From: Hornby, Mark [Mark.Hornby@lancashire.gov.uk]
Sent: 09 November 2012 11:16
To: Graeme Thorpe
Cc: ENV EPP Customer Service Area East
Subject: FW: Consultation on 3/2012/0850 - land at Preston Road Longridge
 Graeme

The existing access to Grimbaldeston Farm from B6243 Preston Road is suitable to serve these two additional dwellings. The proposed parking and turning facilities are adequate for the type of dwelling proposed. I therefore have no objection to this proposal, subject to the following condition:

CLIENT		DWG STATUS	
MR. B MONKS			
PROJECT / DRAWING TITLE			
PROPOSED SITE PLAN: LAND OFF PRESTON ROAD LONGRIDGE PRESTON			
Drawn	VS	Checked	Date
			JULY 2012
DRAWING No.		REV.	
GA1819 - SP

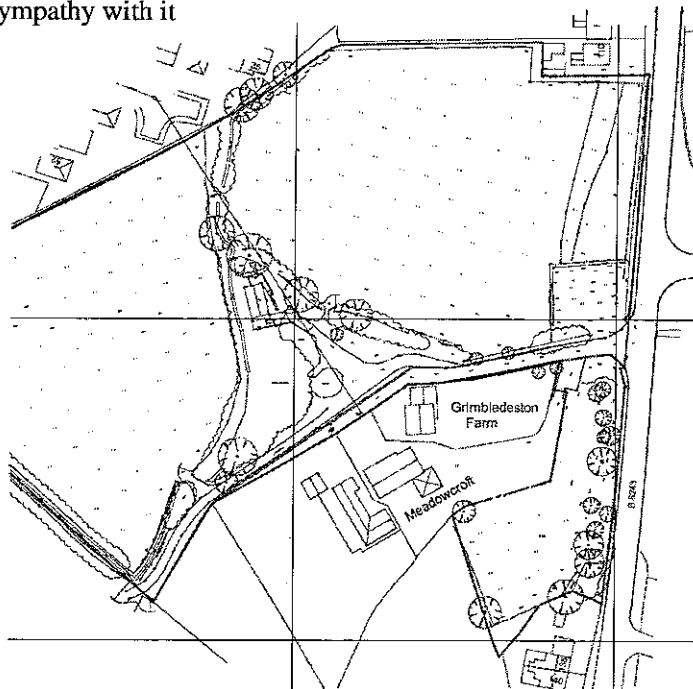
The proposed driveway and parking areas shall be appropriately paved in tarmacadam, concrete, block pavements, or other approved materials. Reason: To prevent loose surface material from being carried onto the public highway thus causing a potential source of danger to other road users.
